Rezoning Transportation Analysis

Petition Number: Insert Zoning Petition #2021-199

Date	Description
12-28-2021	First Review (AO)

DATE: 08/10/20	MPIC: CCB
DRAWN BY: MJA	CHECKED BY: DCT
PROJECT NUMBER: 00889-00	
SCALE: 1" = 10'	
TITLE: CONCEPTUAL SITE PLAN

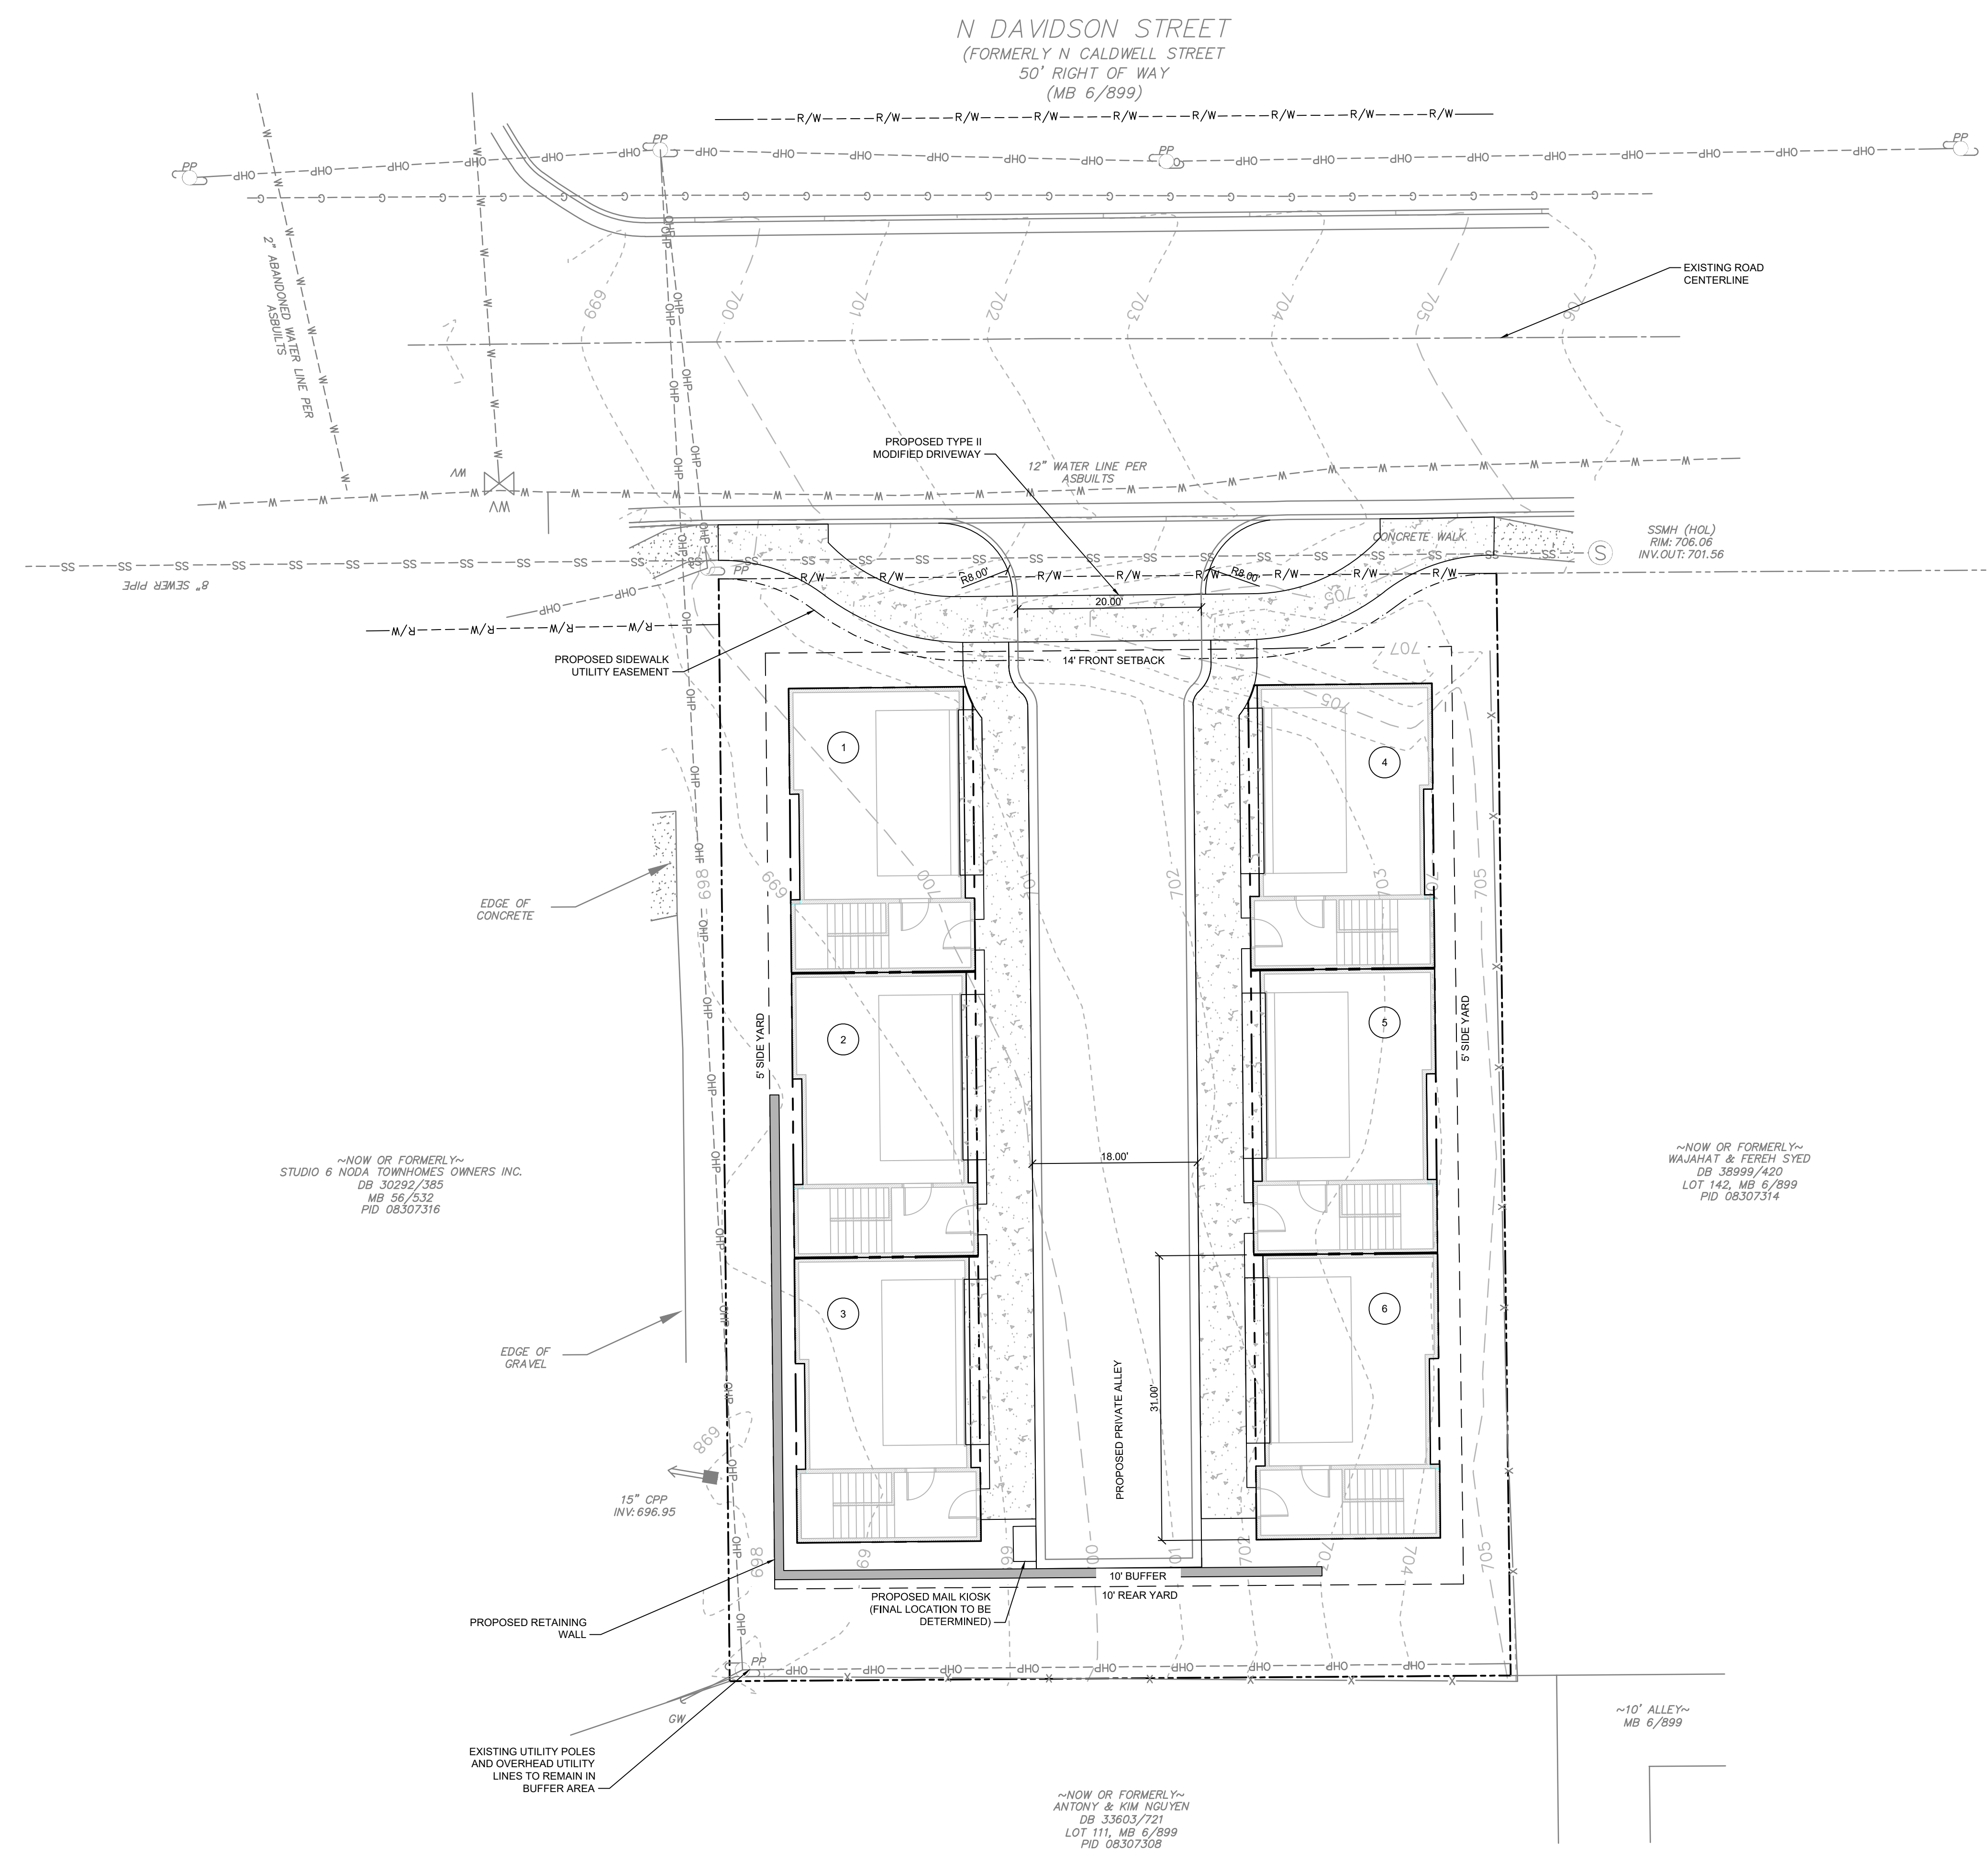
Label and dimension the curb and gutter from the centerline for each road on the site plan.

3. Revise site plan and conditional note(s) to commit to dedicate 35' of right-of-way from the road centerline. The site plan shall label and dimension the right-of-way from the road centerline.

4. Revise site plan and conditional note(s) to commit to construct an 8-foot planting strip, and 8-foot sidewalk on N Davidson St per Chapter 19 & Chapter 20. The site plan shall label and dimension both items from the back of curb and gutter and road centerline.

5. The proposed dwelling units exceeds 12 per acre. Per Chapter 20 Subdivision ordinance, site plan and conditional note(s) revisions are needed to commit to construct an 8-foot planting strip, and 8-foot sidewalk along N Davidson St. The wider sidewalk also meets the Charlotte WALKS Policy.

6. Revise site plan to show maintaining planting strip along entire frontage and square off sidewalk. Maintain consistent 2' Sidewalk Utility Easement behind the back of sidewalk.

7. Revise site plan to show correct dimension for minimum driveway width per CLDSM 10.25E for Type II Modified Driveway based on operation and radius.
8. A site plan note(s) specifying dedication and fee simple conveyance of all rights-of-way to the City before the site's first building certificate of occupancy is issued is needed. CDOT requests rights-of-way set at 2' behind back of sidewalk where feasible.
9. A site plan note specifying that all transportation improvements will be approved and constructed before the site's first building certificate of occupancy is issued is needed. The petitioner may phase transportation improvements if said improvements and phasing are explicitly described in site plan notes.
